From: [REDACTED]
Sent: 17 December 2024 11:47
To: Planning
Subject: Planning Application 3/2024/0788

Re: planning application 3/2024/0788

I am writing in reply to your letter dated 4 December 2024 regarding planning permission for 1 Wheatley Drive.

PROPOSED ELEVATIONS

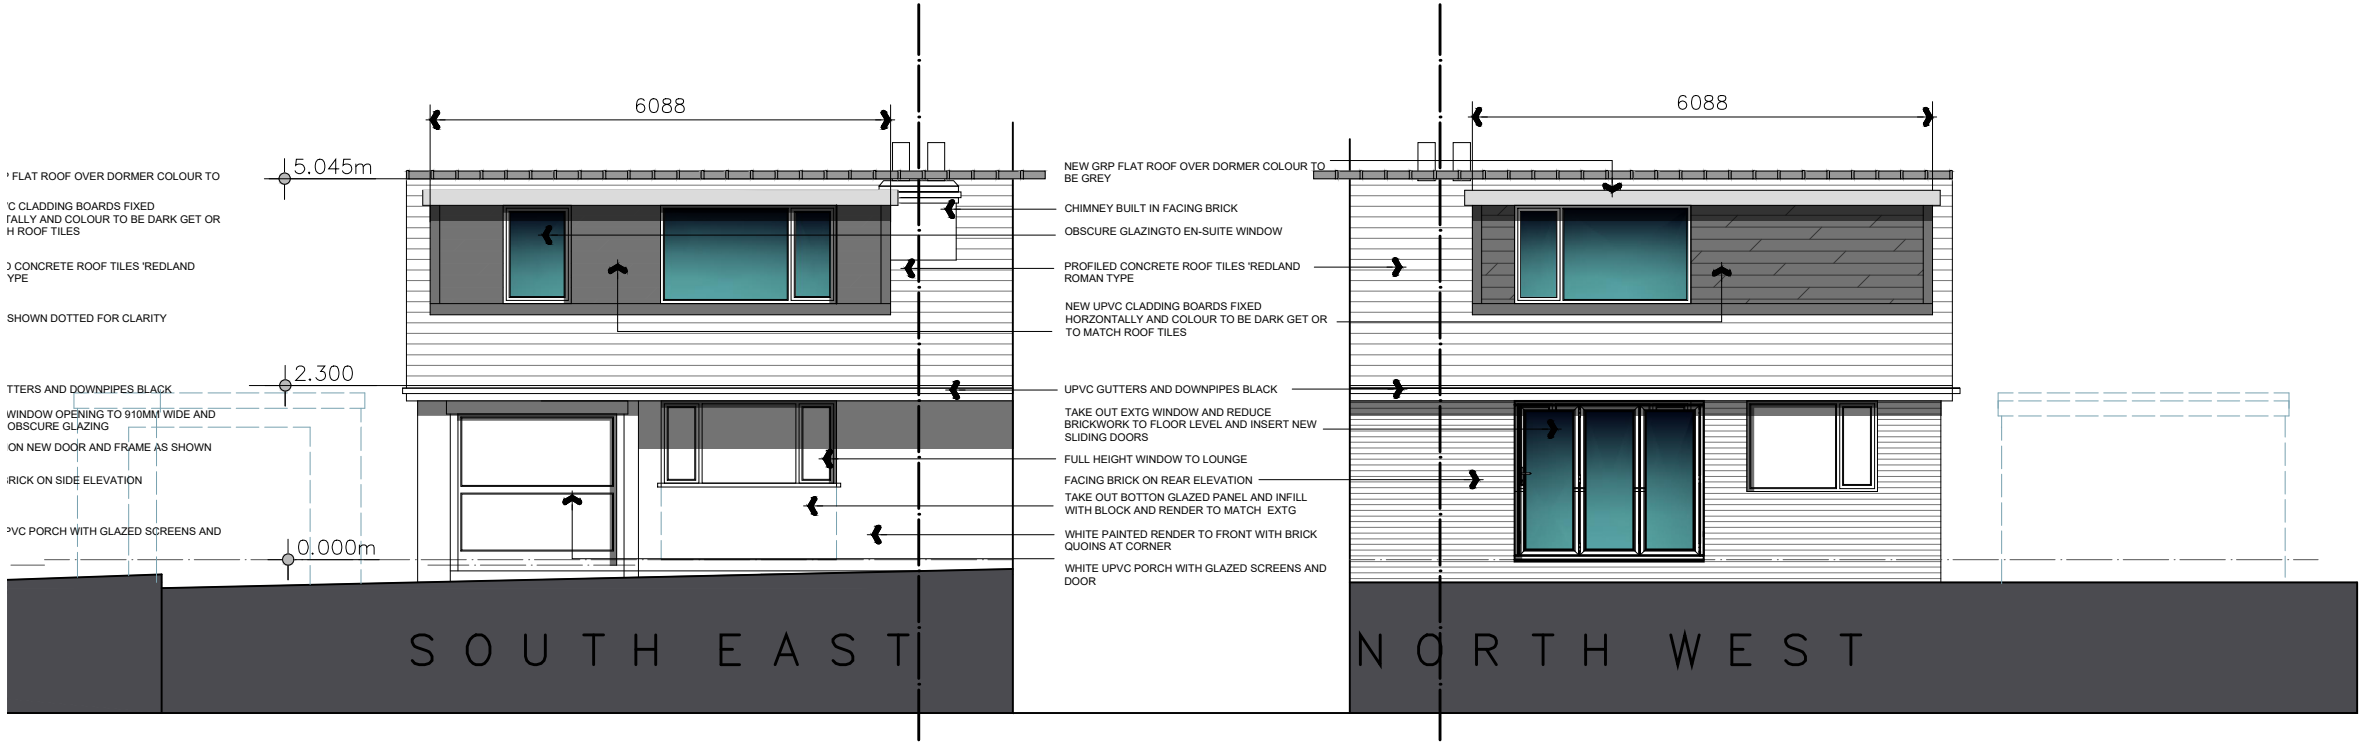
I would like to submit the following comment. I have a concern about the chimney heights above the roof line with the proposed dormer extension. I don't believe the chimneys will be high enough away from the dormer.

I believe there are regulations regarding this in the Local Authority Building code Approved Document J. This document outlines the minimum outlet heights and distances from opening windows.
